Application Ref:	3/2021/0445	 Ribble Valley Borough Council www.ribblevalley.gov.uk
Date Inspected:	04/06/2021	
Officer:	AB	
DELEGATED ITEM FILE REPORT:		REFUSED

Development Description:	Proposed change of use from office hub to dwelling.
Site Address/Location:	The Brows Farm Brows Barn Higher Road Longridge Preston PR3 2YX

EXISTING FLOOR PLANS

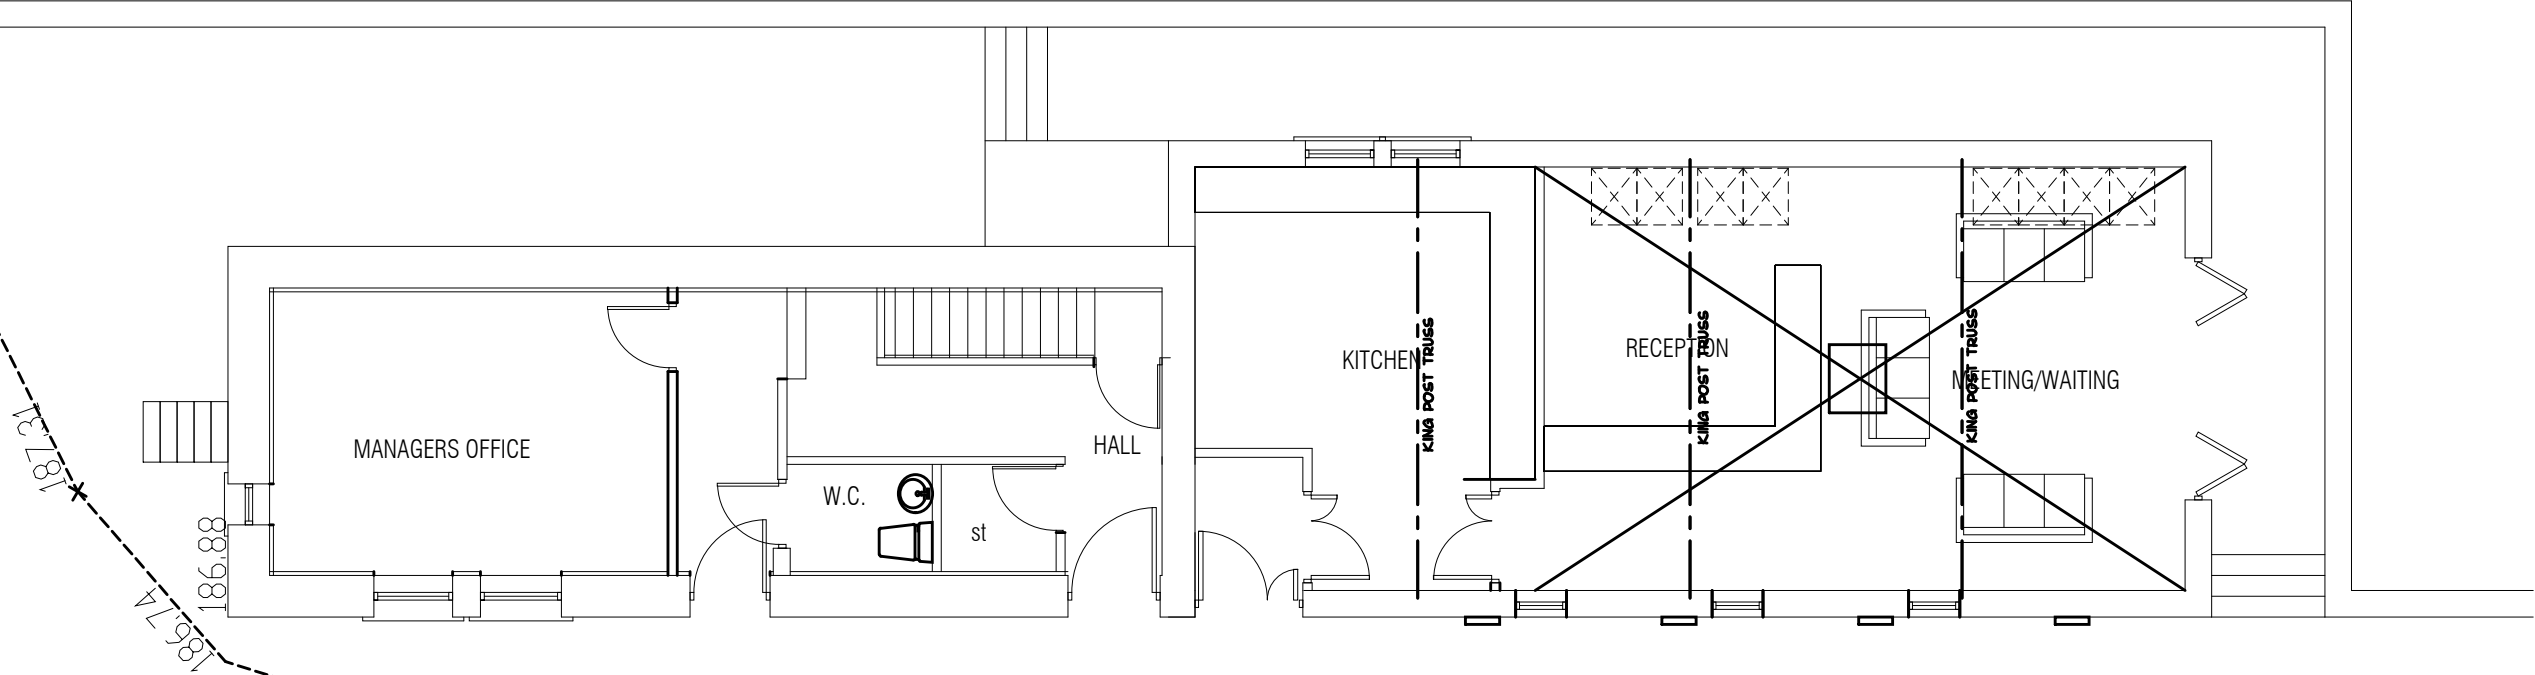
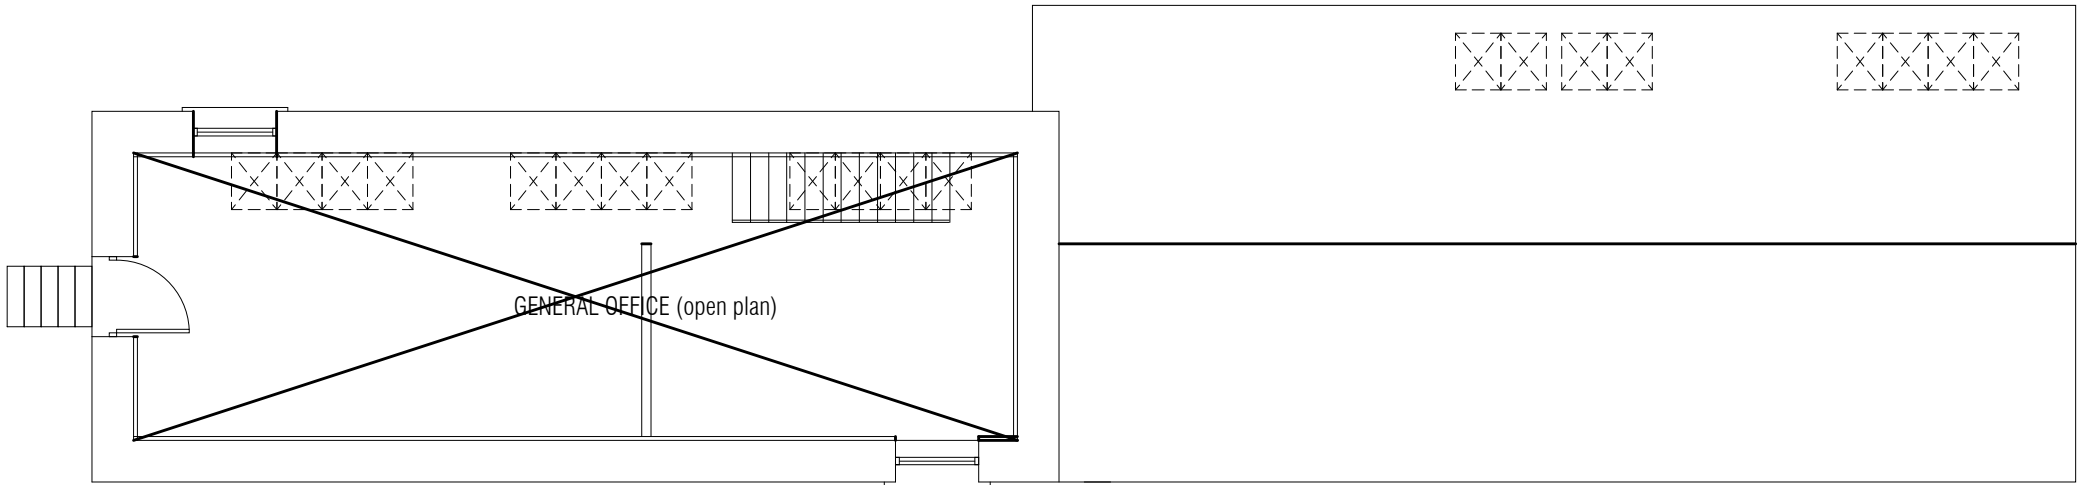
This is a full planning application for the change of use of an office hub to a dwelling at The Brows Farm, Brows Barn, Higher Road, Longridge. When compared with the building at present there are no changes proposed externally as part of this application. Internally, the floor plan would be altered to provide a two-bed dwelling.

Drawing Title
PROPOSED SITE PLAN

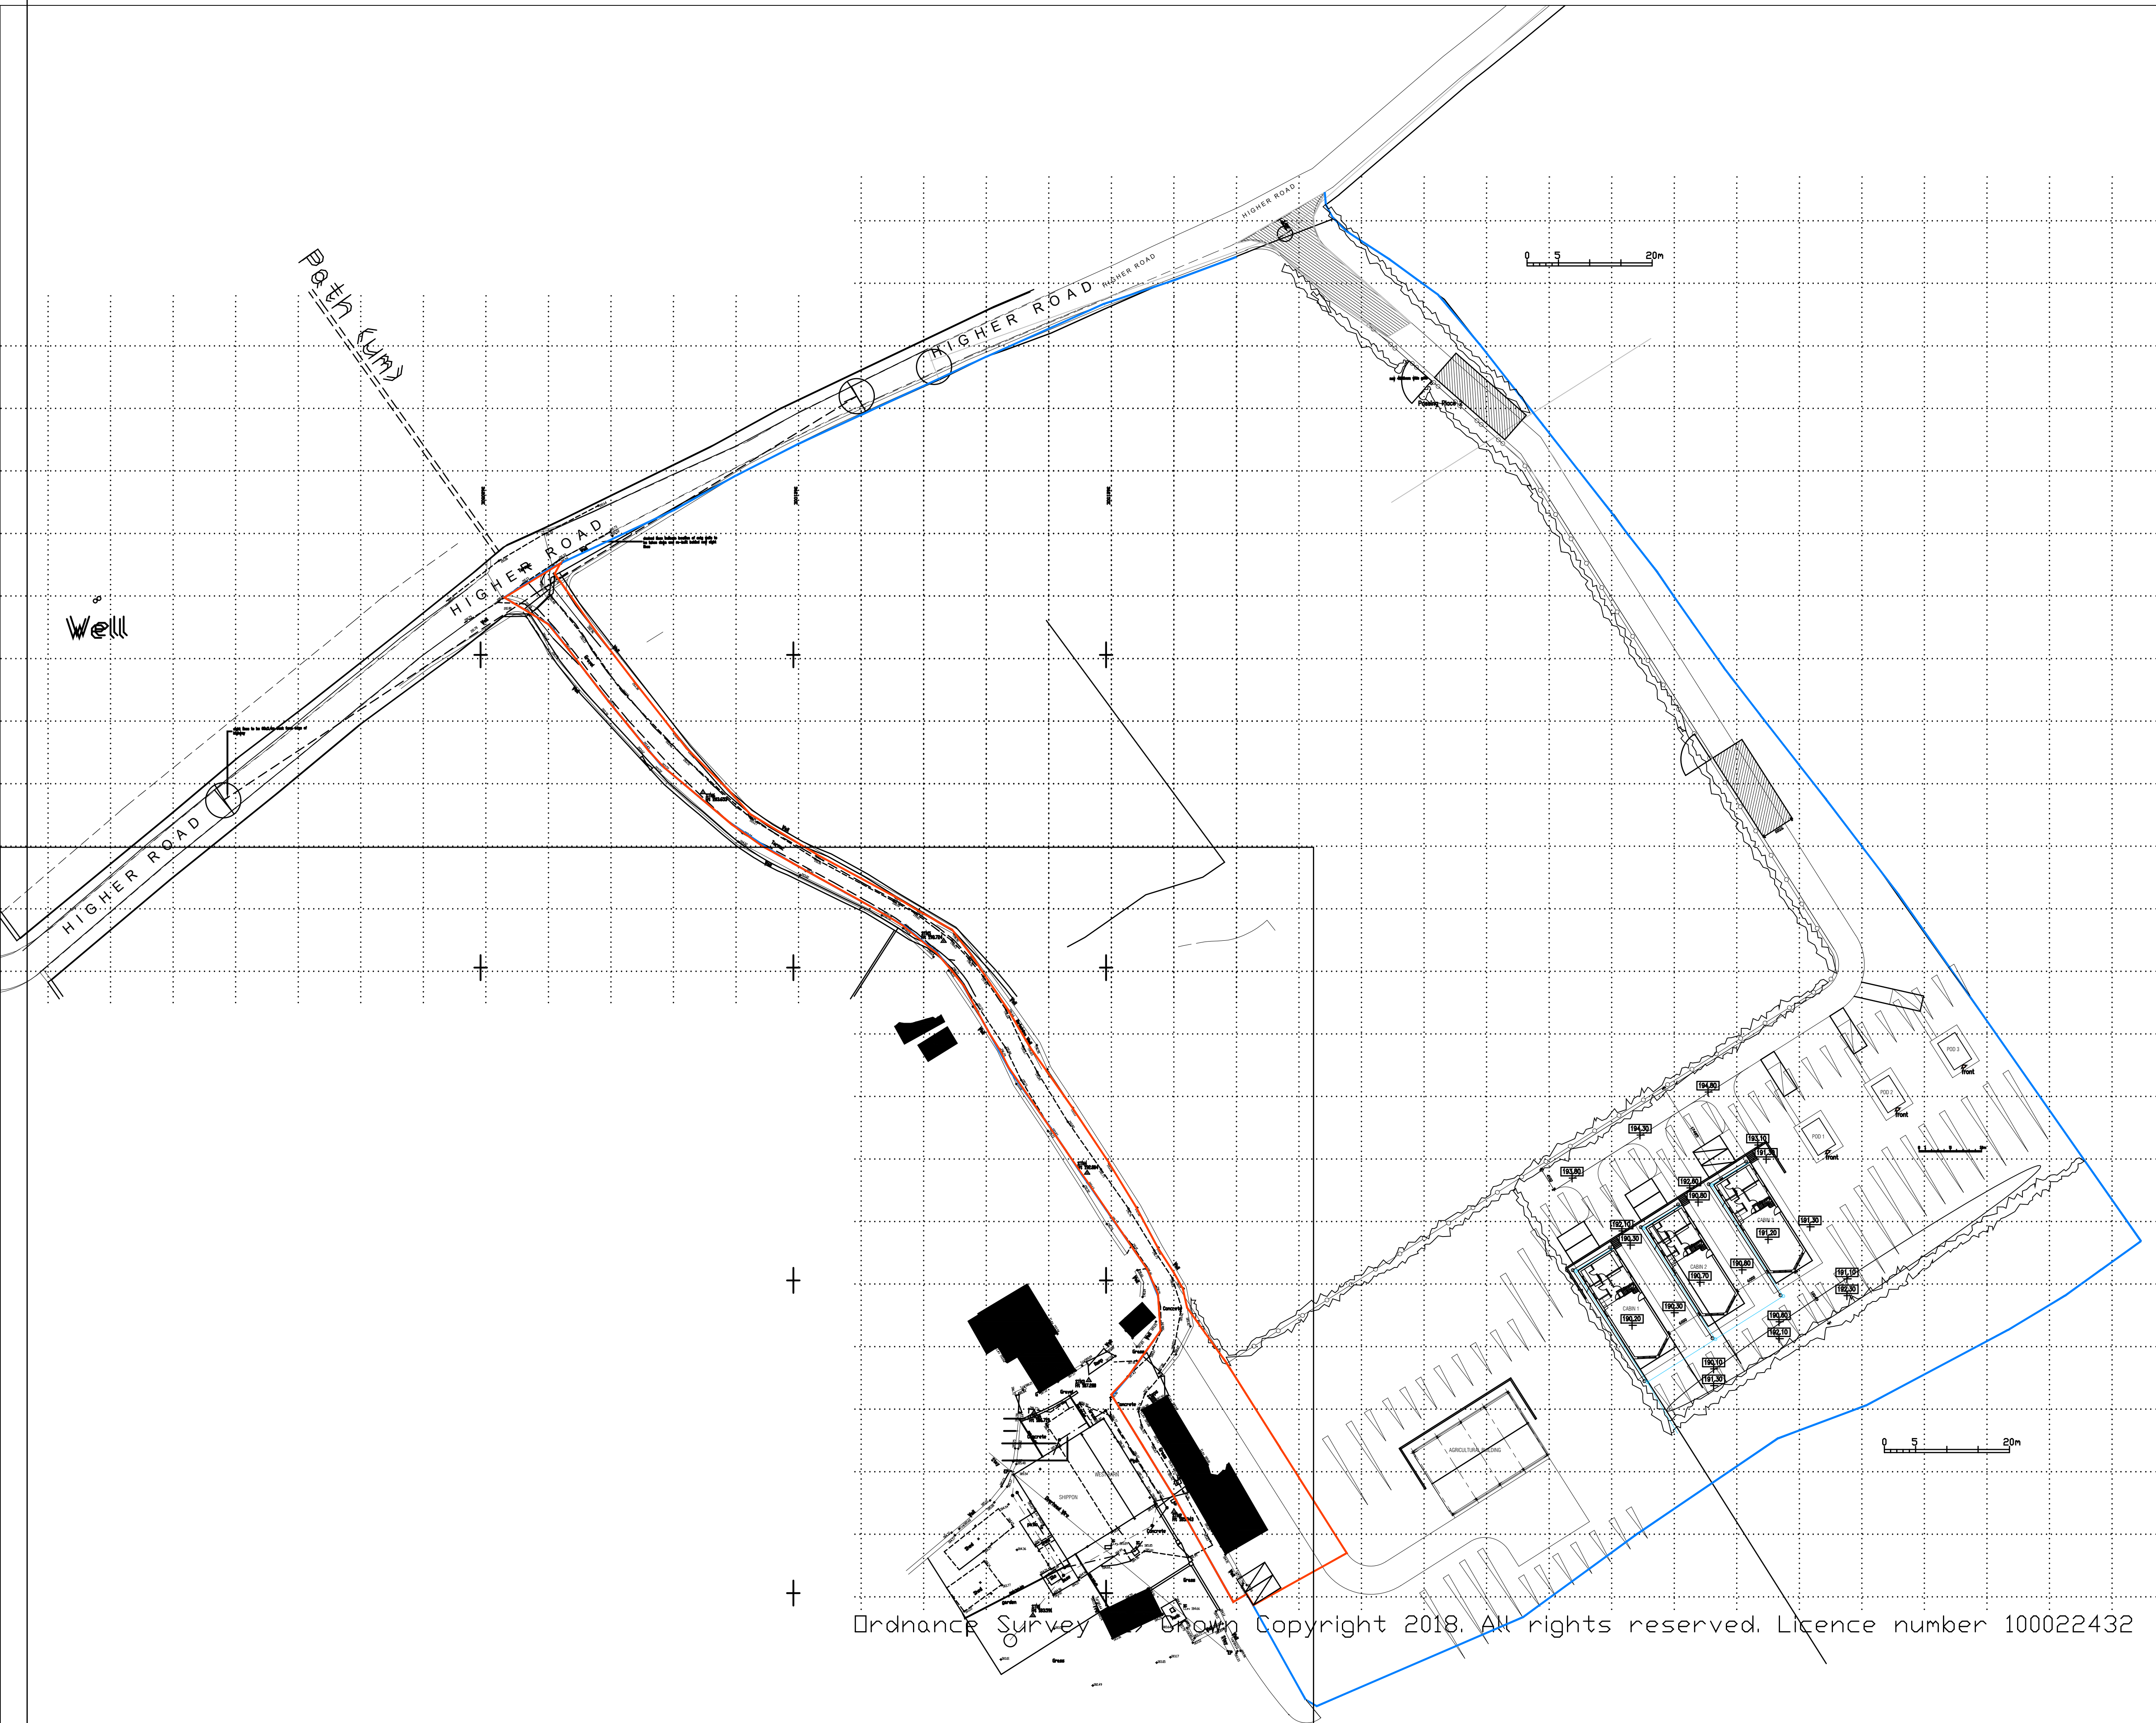
However, it was noted during a visit to the site that the building has not been converted strictly in accordance with the approved plans with some additional window openings and other irregularities. Most concerning of these is the creation of a garden area bound by stone walls to the south of the building.

As submitted, the plans indicate that there would be no change to elevations or the visual appearance of the development. However, as noted above, the conversion of the building has not been completed

in accordance with approved plans. A garden area has been created and there was evidence that the building is already being used as a permanent dwellinghouse, including domestic paraphernalia.

Taking into account the development as previously approved, the change of use of the building to a dwellinghouse would have an additional visual impact due to the extension of the planning unit and creation of a private garden area. The applicant should seek to regularise any unauthorised changes to the building and site layout as part of any future application.
